**ADC Planning Consultation
Response from the Historic Buildings Adviser**

Application Number	A/138/13
Address	Site to the rear of The Old House, High Street, Angmering BN16 4AG
Description	Outline application for the erection of detached dwelling house - This application affects the setting of a Listed Building.
Case Officer	Anita Gardner
Site Visit

FRONT
PROPOSED ELEVATIONS
Scale 1:100

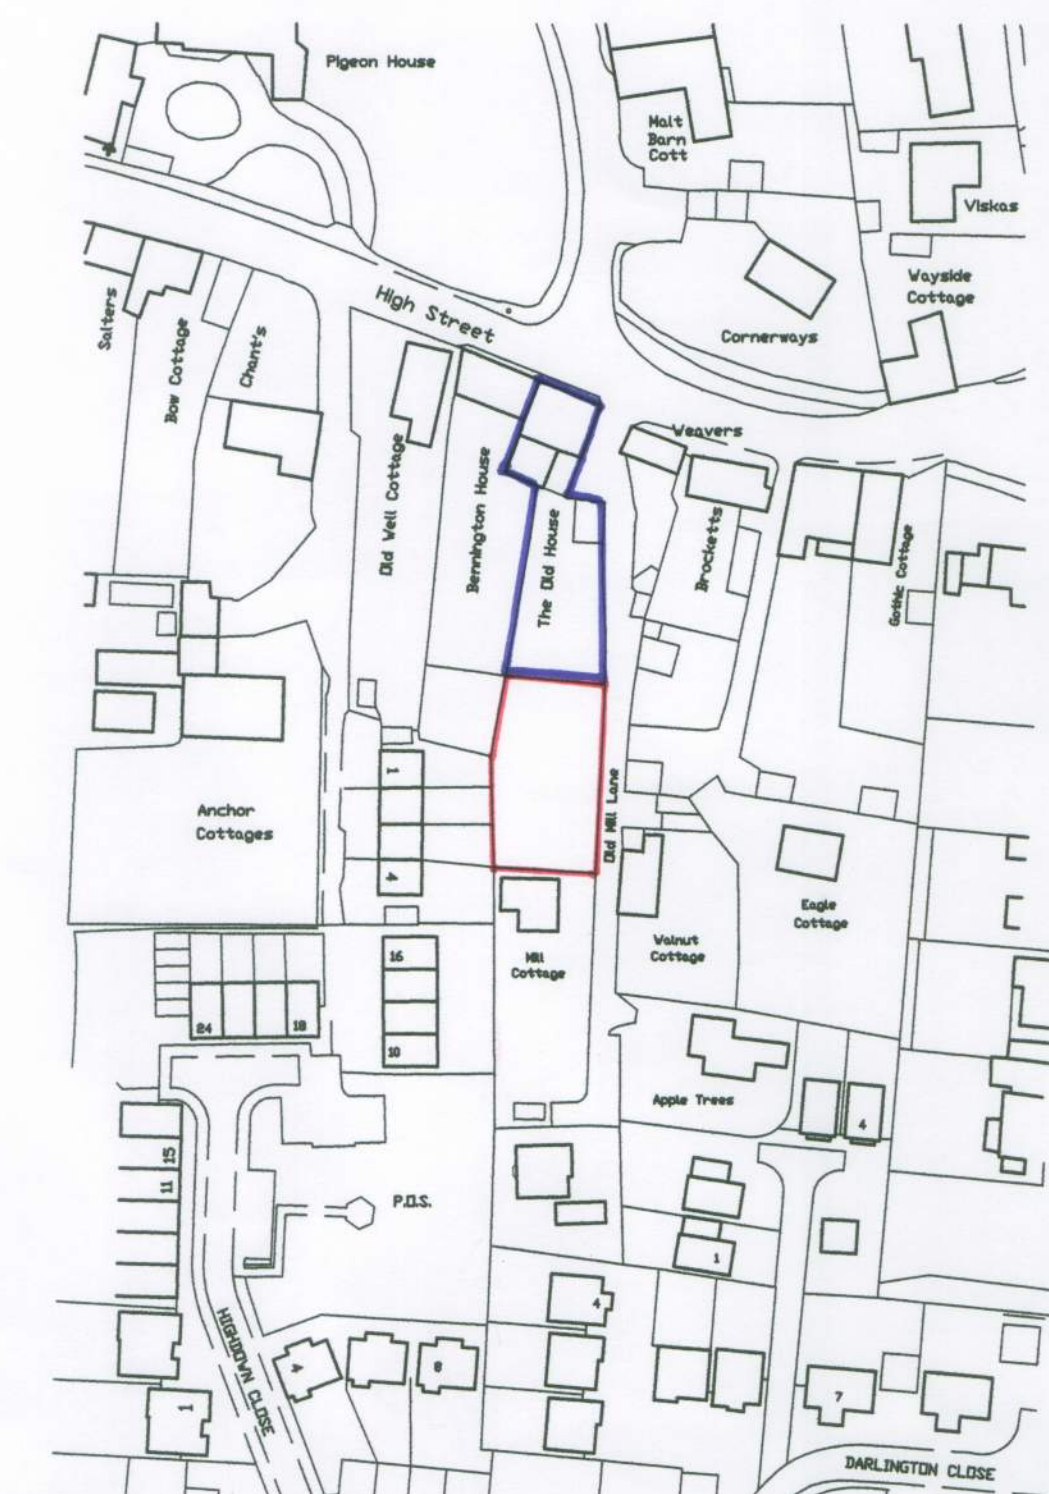
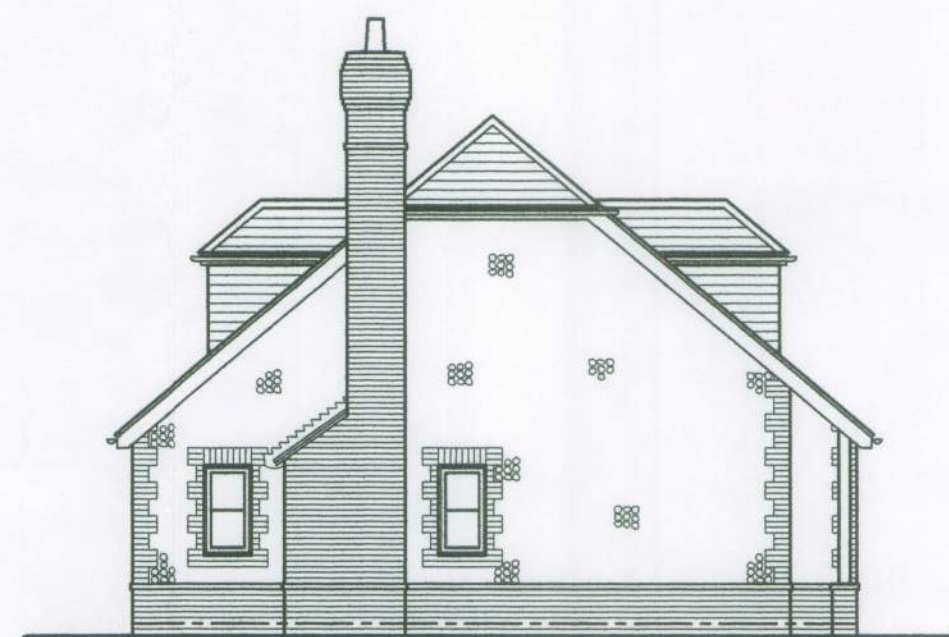
Where the principle of development is considered justified, new buildings should be of a high design quality to mitigate their impact. I am afraid the chalet style bungalow proposed here would not meet this test.
